PORTLAND MAINE

March 31, 2008

RE: 11 Oakland Avenue, Peaks Island – 084 C010 – IR-2 – rebuild deck – Permit # 08-0268

100.633' 11 OAKLAND AVE
PLOT PLAN 1" = 10'

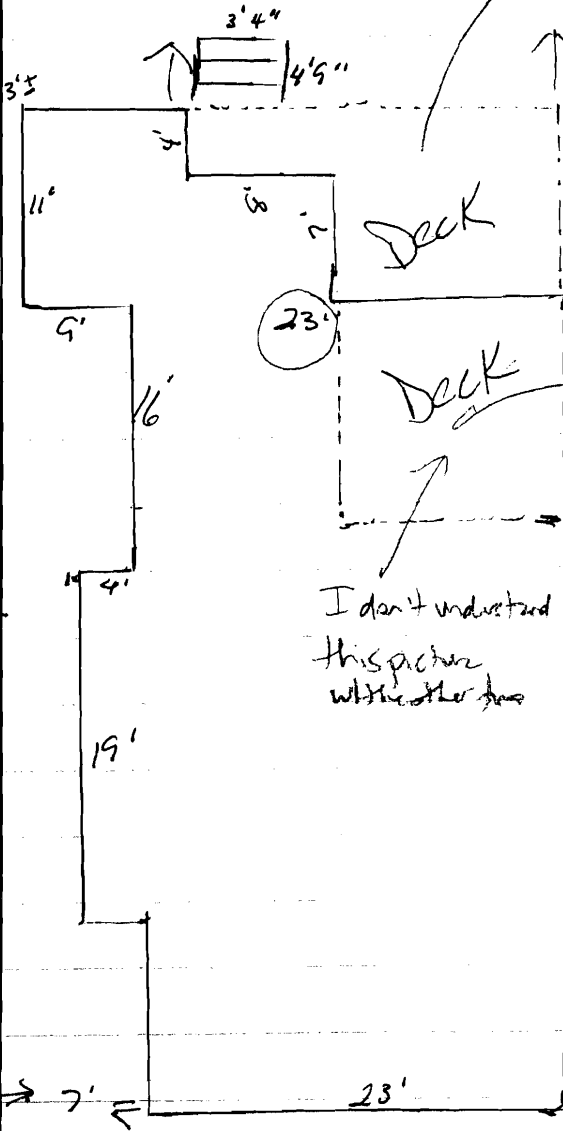
The existing deck cannot be permitted because it does not meet the requirements of the IR-2 zone. Section 14-145.11(d) of the ordinance states that the maximum lot coverage allowed in the IR-2 zone is twenty percent of the lot. Your lot is 5,031 square feet, so twenty percent of that is 1,006.6 square feet. The footprint of the permitted part of the building not including the deck is 1,239 square feet, so your building is already non-conforming to the maximum allowable lot coverage. You are not allowed to make your property more nonconforming. Also, it is not clear that the deck would meet the rear setback of twenty-five feet - section 14-145.11(c)(2). The plot plan shows that the rear setback to the deck is twenty-five feet, but the numbers show that the rear setback is just less than twenty-four feet (23.63) to the deck and the steps are closer to the rear property line.

You have the right to appeal my decision. If you wish to exercise your right to appeal, you have thirty days from the date of this letter in which to appeal. If you should fail to do so, my decision is binding and not subject to appeal. I have enclosed the necessary paper work that is required to file an appeal. If you choose not to file an appeal, you are entitled to get most of your money back if you bring in the original receipt you got when you applied for the permit. If you chose not to appeal, then the existing deck must be removed within thirty days to bring the property into compliance.
